# ROADWAY PLANS WYOMING ESTATES SUBDIVISION EL PASO COUNTY, CO

PCD PROJECT NO. MS196

DRAINAGE, GRADING
AND EROSION
CONTROL PLAN

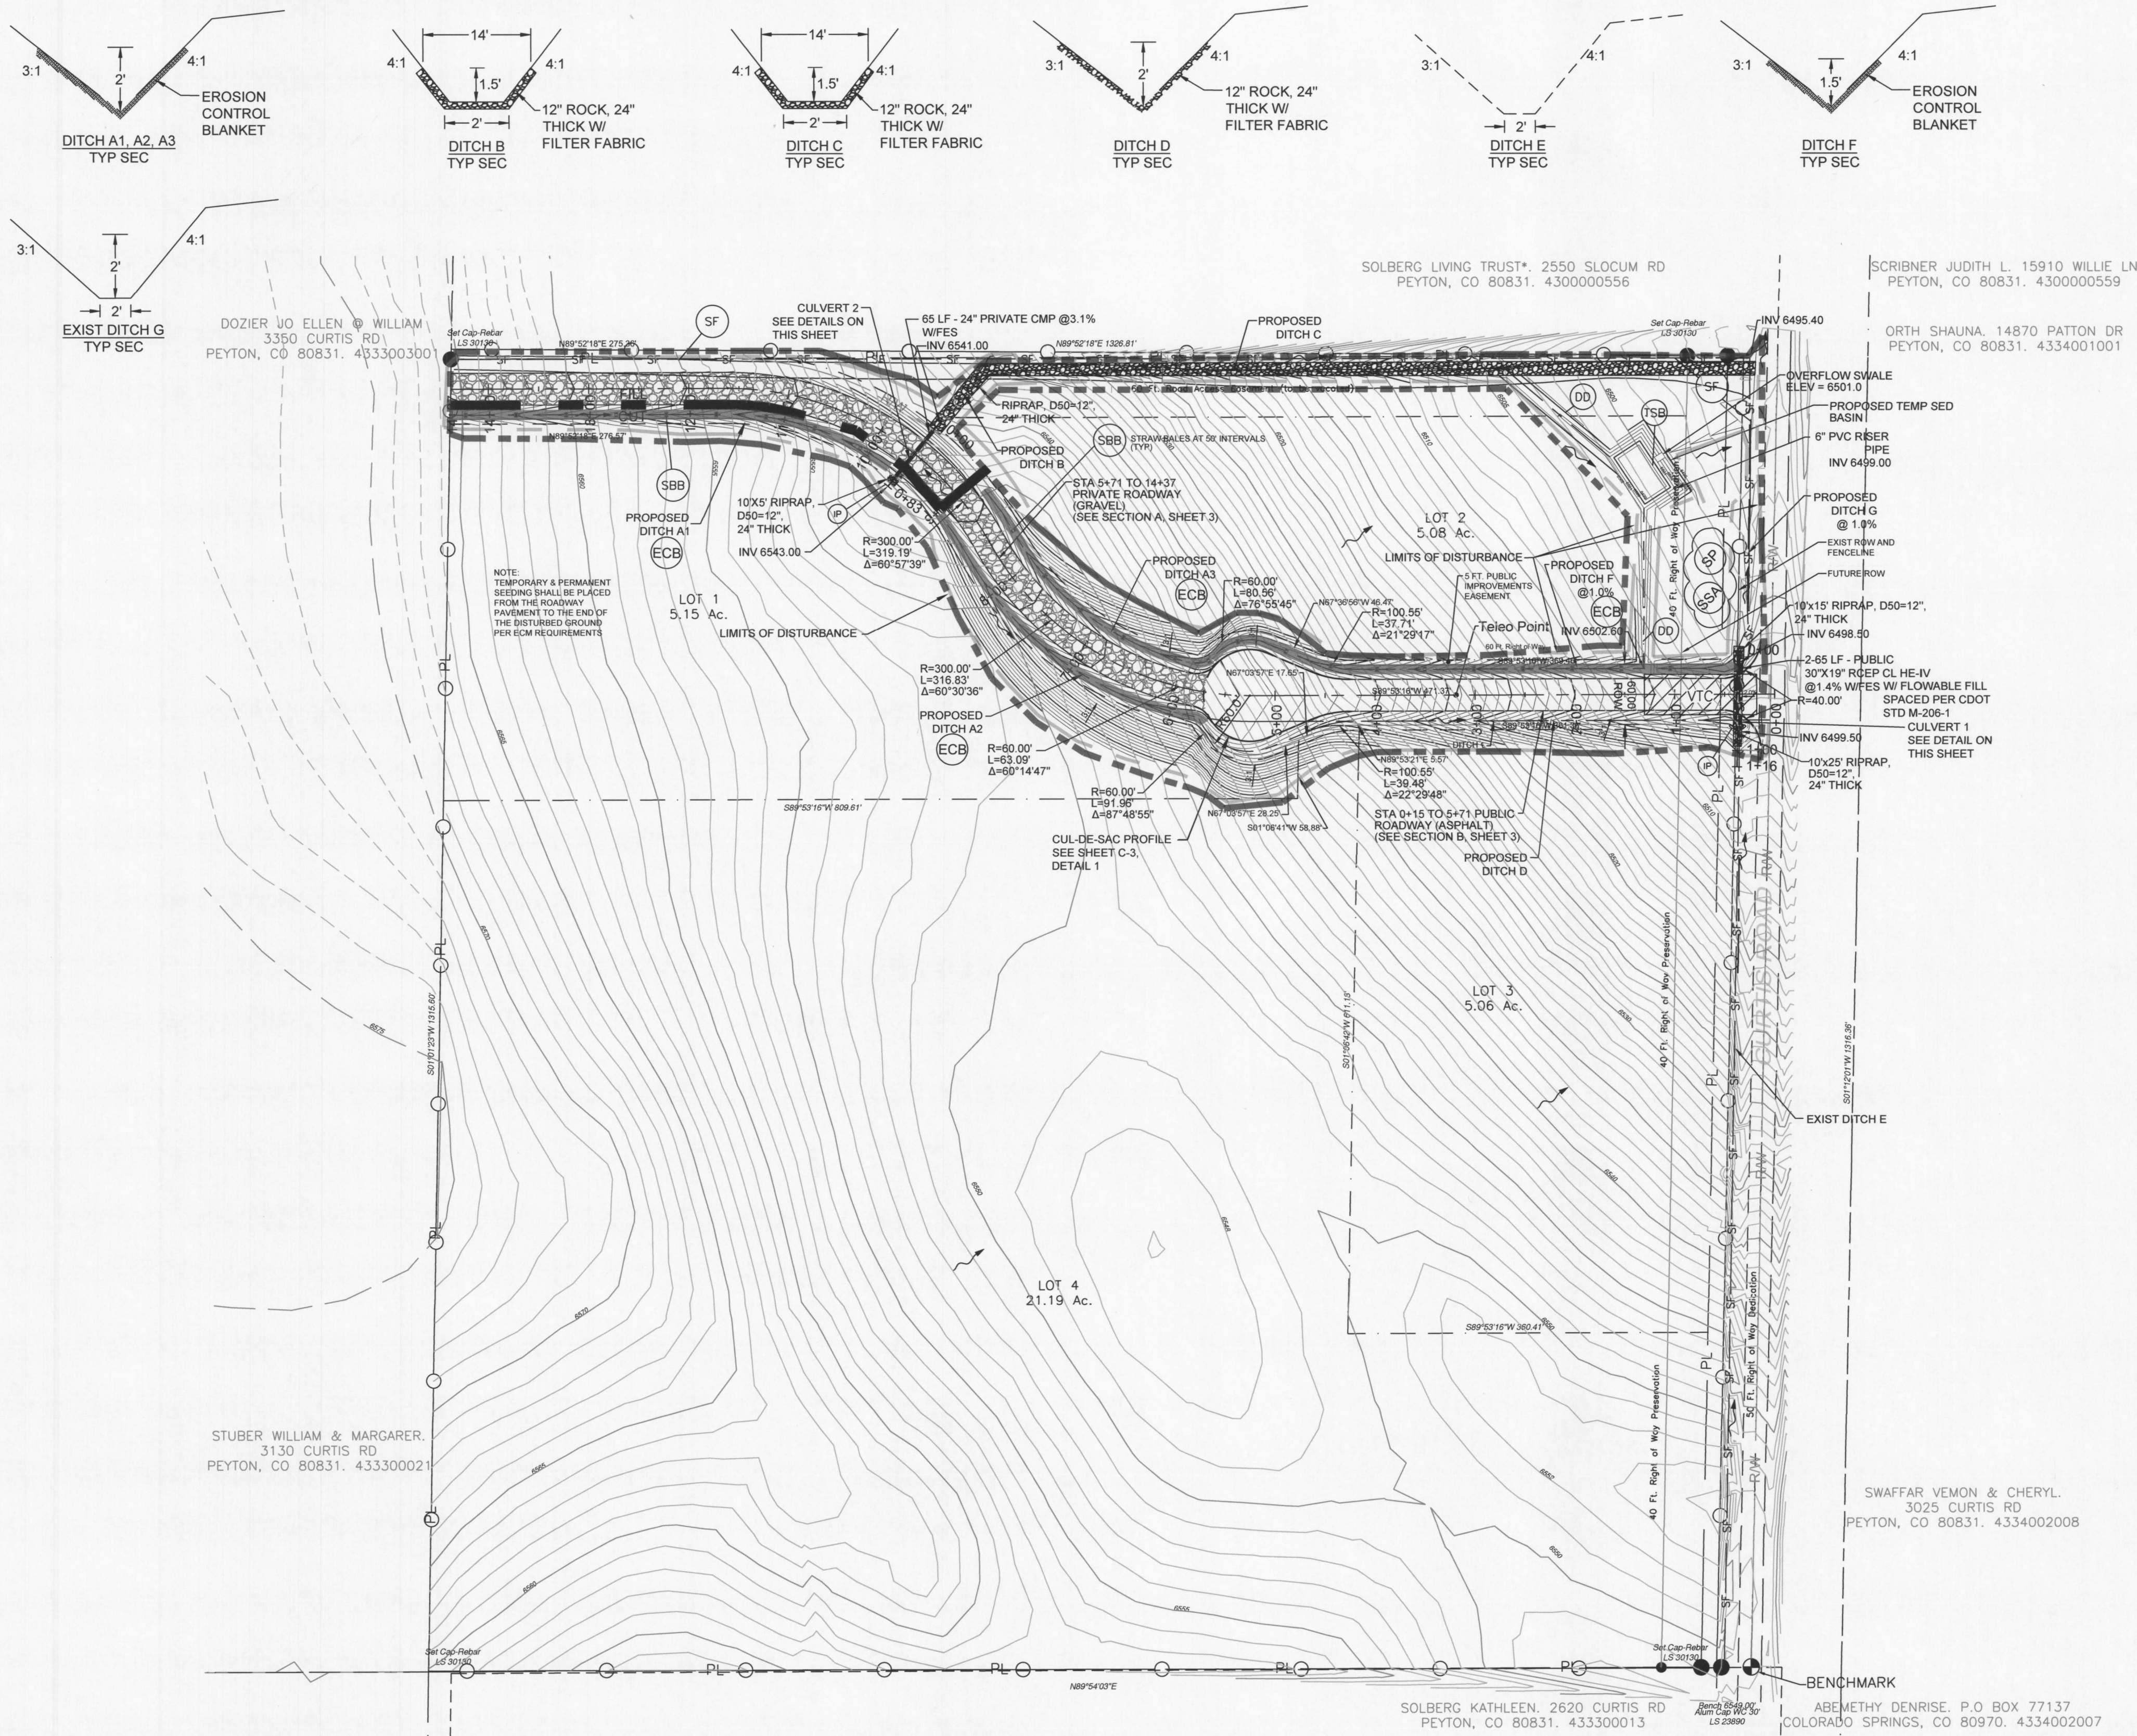
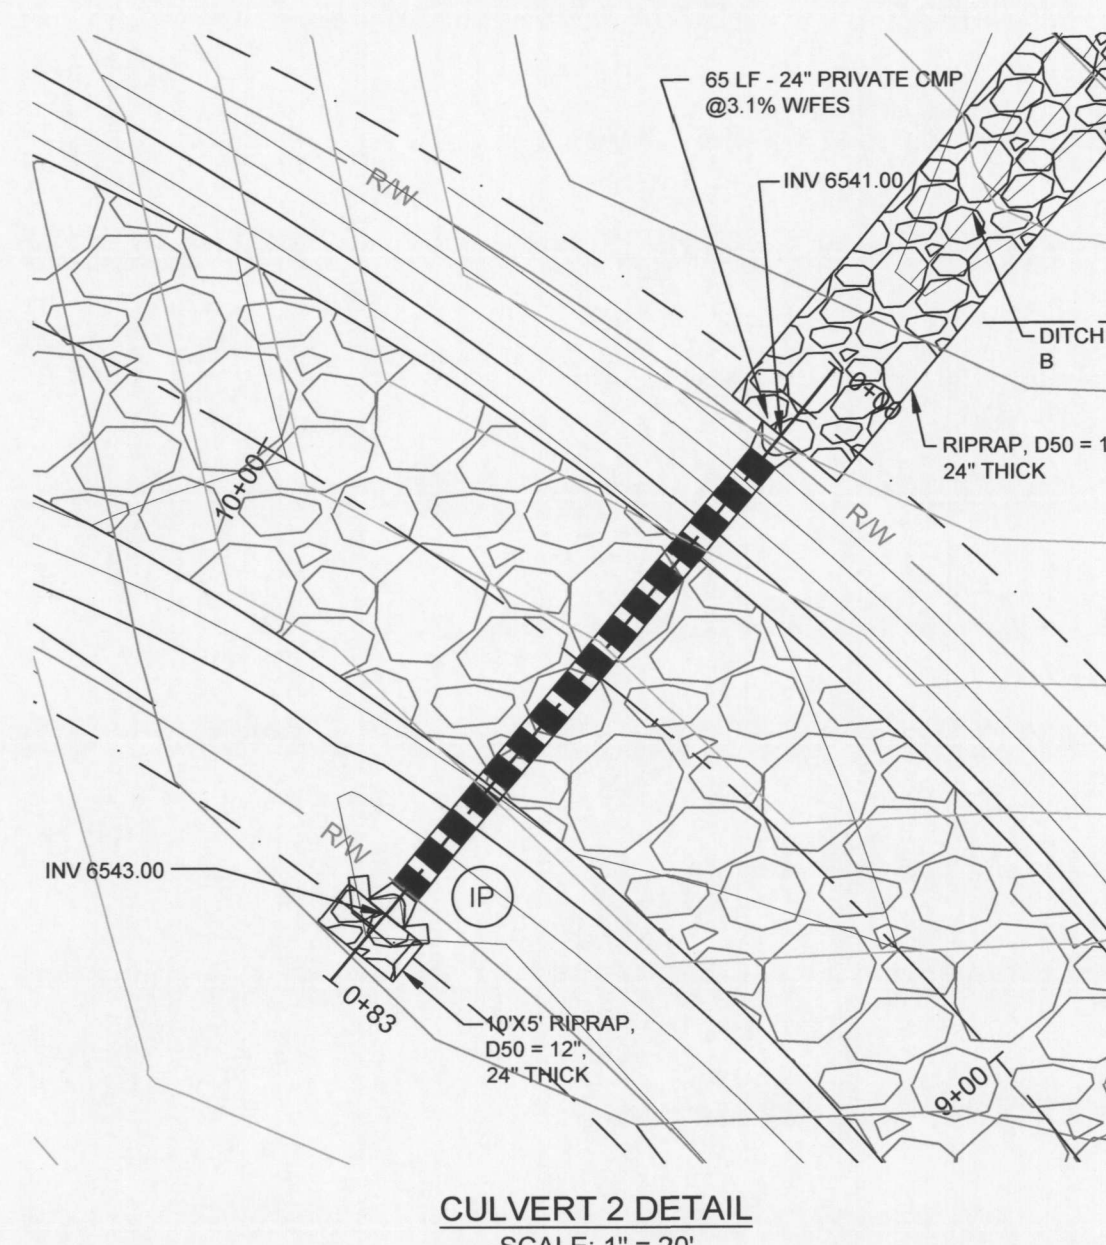
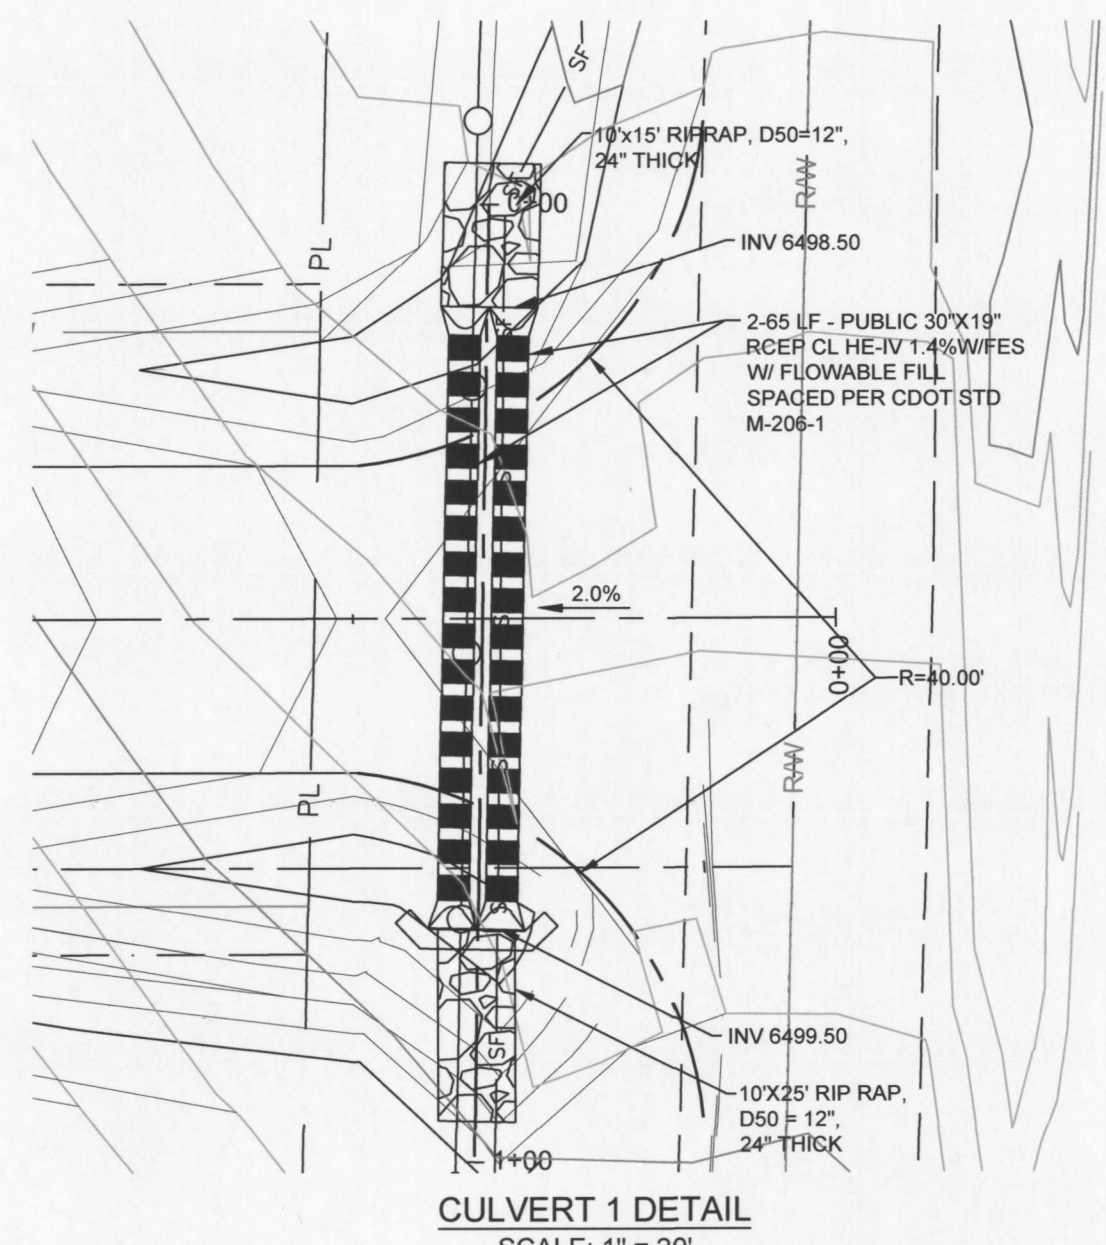
Review 2 comment:  
Please provide the appropriate construction documents for any permanent stormwater quality control measures  
Review 3: Unresolved. Please provide pond details for the proposed water quality pond.

PROJ NO. 03433
 DWG NM. 03433-GrdgEros

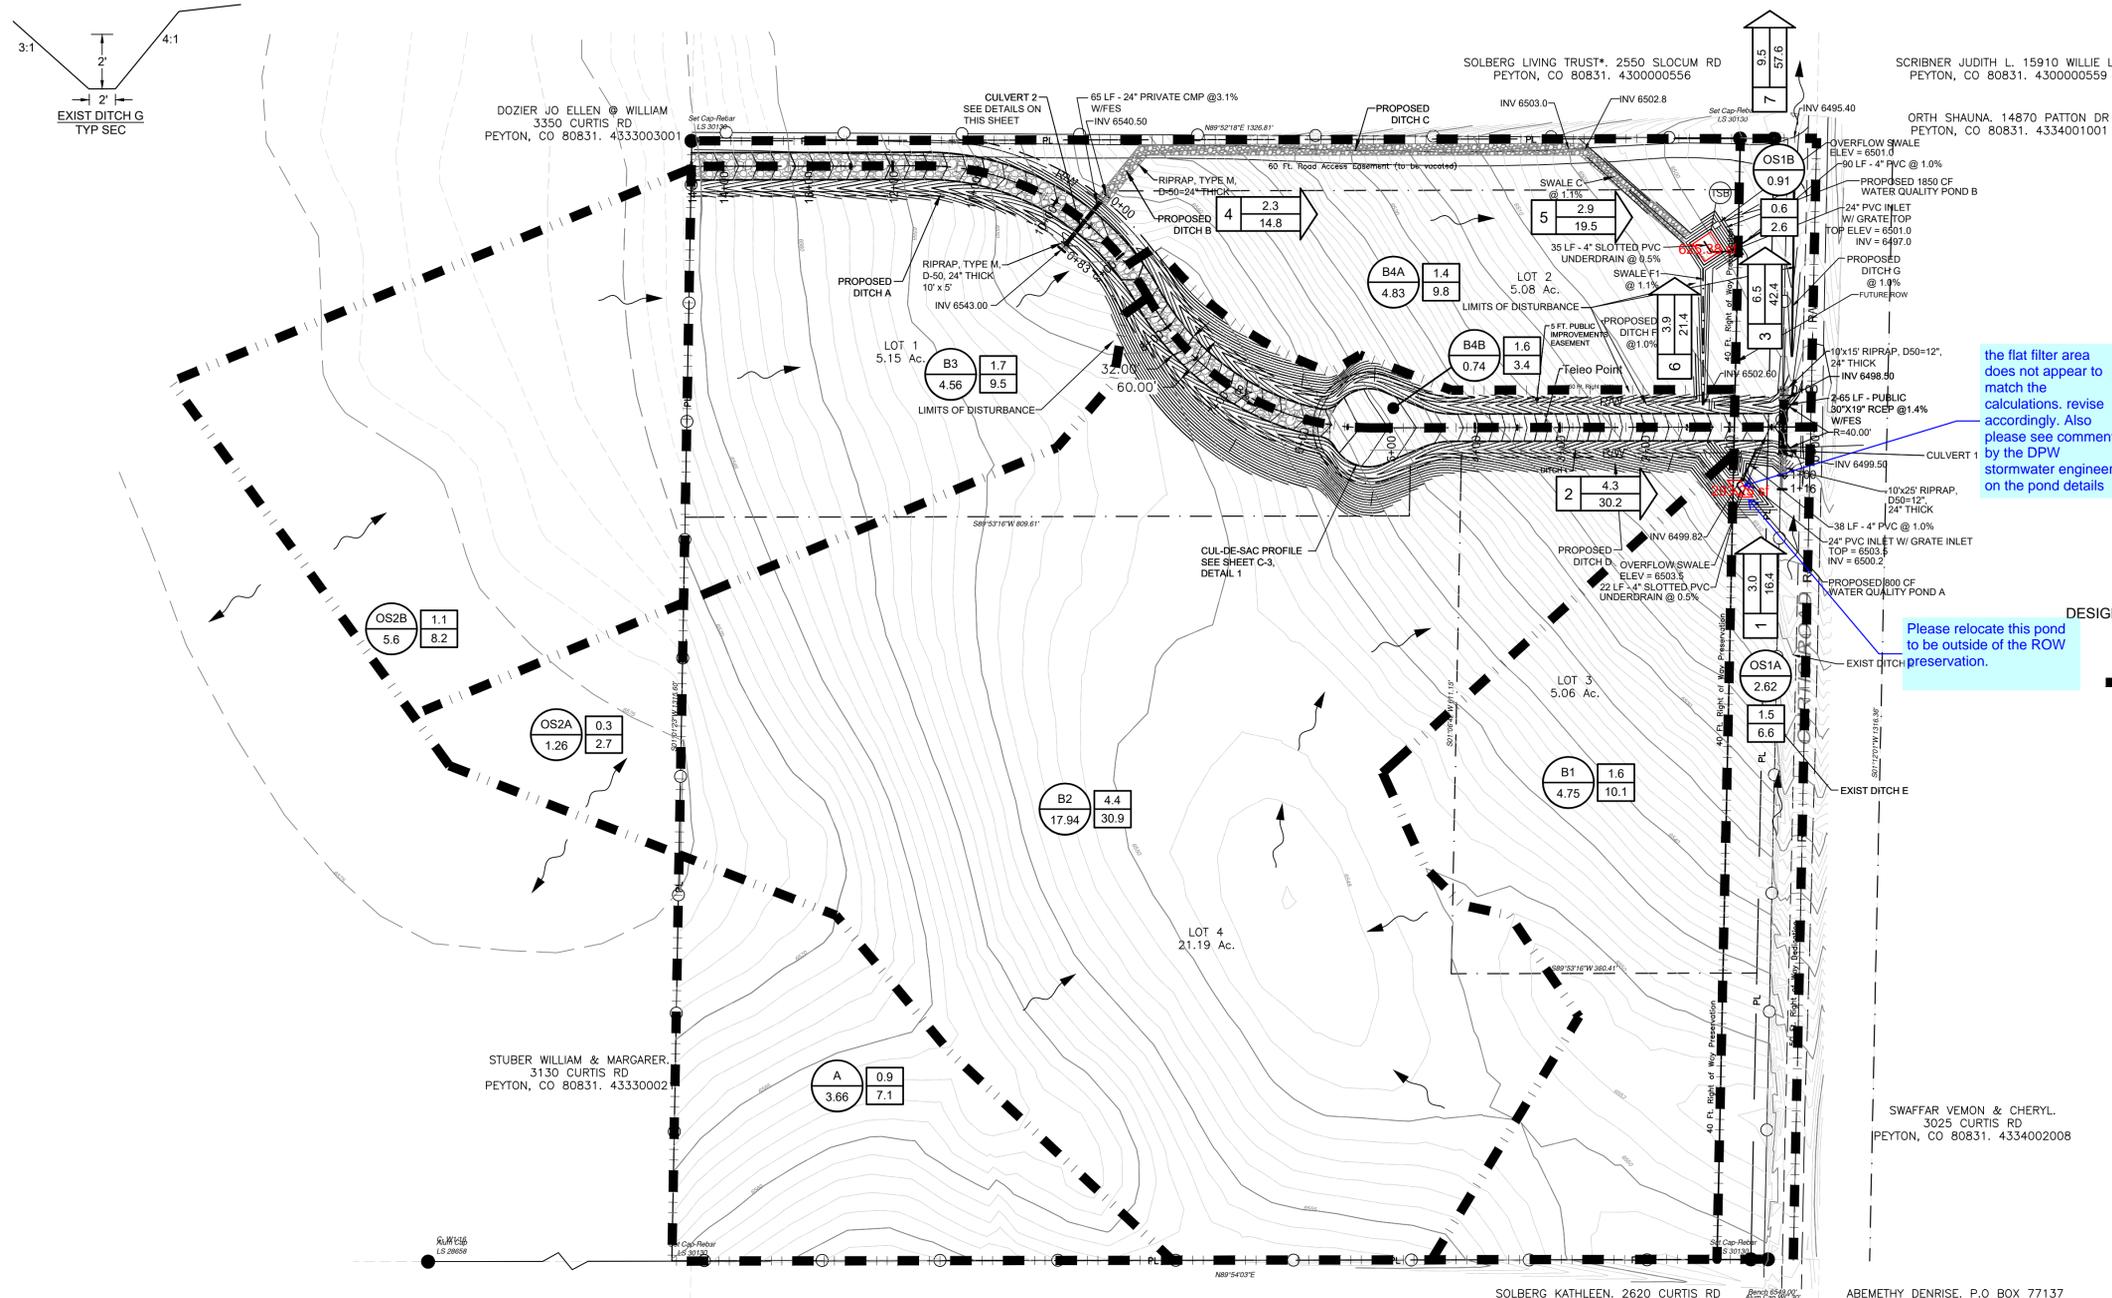
Review 1:  
Is this for bidding purposes? If so please indicate it with a footnote. Final pavement design shall be provided in a pavement report for review and approval by PCD.  
Review 2: Unresolved. Add a footnote that the indicated pavement section is an estimate or that it is for bidding purposes. A final pavement design shall be provided for review and approval prior to any paving.  
Review 3: Unresolved
